TO: Mike Elkins, Staff Planner, Community Development Services
FROM: Randy Carbary, Planner II *rc*
DATE: February 12, 2008
SUBJECT: Clapper Short Plat

RE: Clapper Short Plat (SP-07-156)

SUBJECT: Clapper Short Plat

<b>K.C.S.P. NO. 07-XX</b>			
Portion of the NW1/4, Sec. 20 T.18N., R.18E., W.M.			
Kittitas County, Washington			
DWN BY	DATE	JOB NO.	SHEET
T.R./G.W.	10/07	07195	1 OF 2
CHD BY	SCALE		
D. NELSON	1"=200'

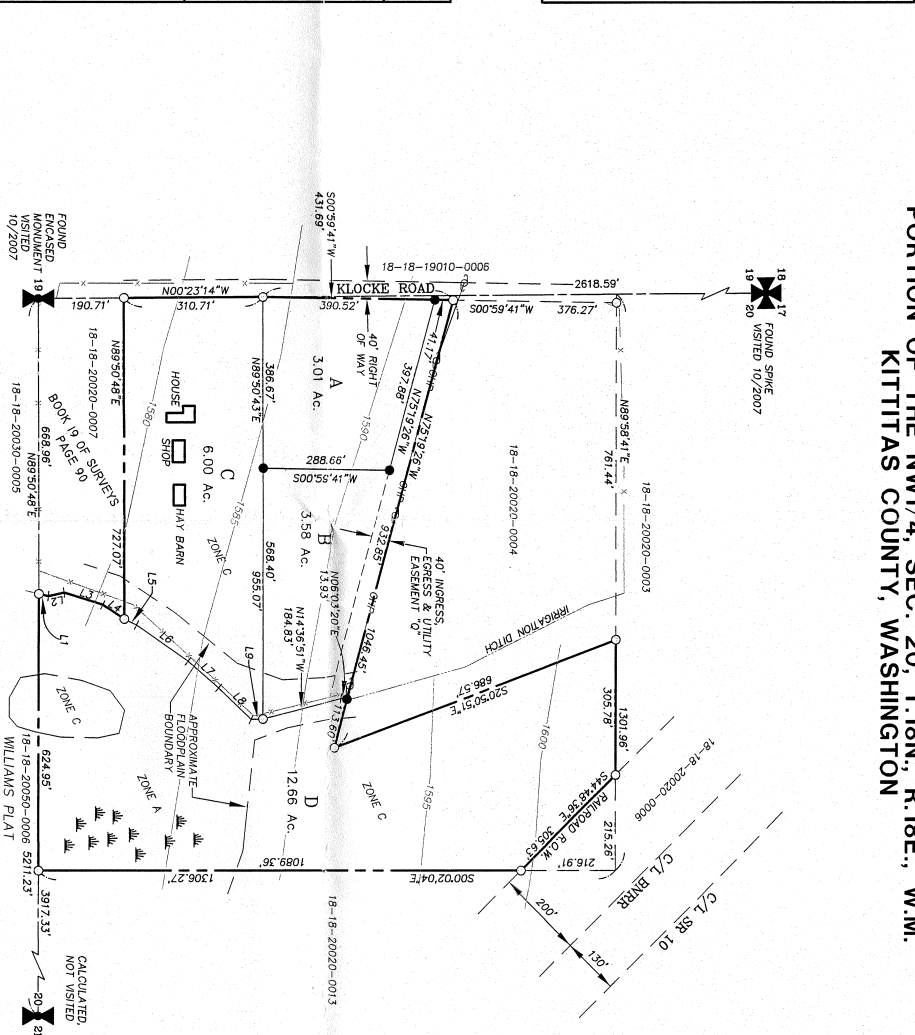
Thank you for the opportunity to comment on the above referenced project. The file indicates soil logs need to be performed. A well log for the existing well on the property has been provided, however, the location of the existing well needs to be identified. Thank you for your time.

Existing Driveway: The existing access (driveway) to lot C shall be shown on the face of the plat. Per Kittitas County Code 16.12.030, Preliminary Plats, Existing Conditions.

Irrigation Ditch: The existing concrete irrigation ditch shall be shown on the face of the plat. Per Kittitas County Code 16.12.030, Preliminary Plats, Existing Conditions.
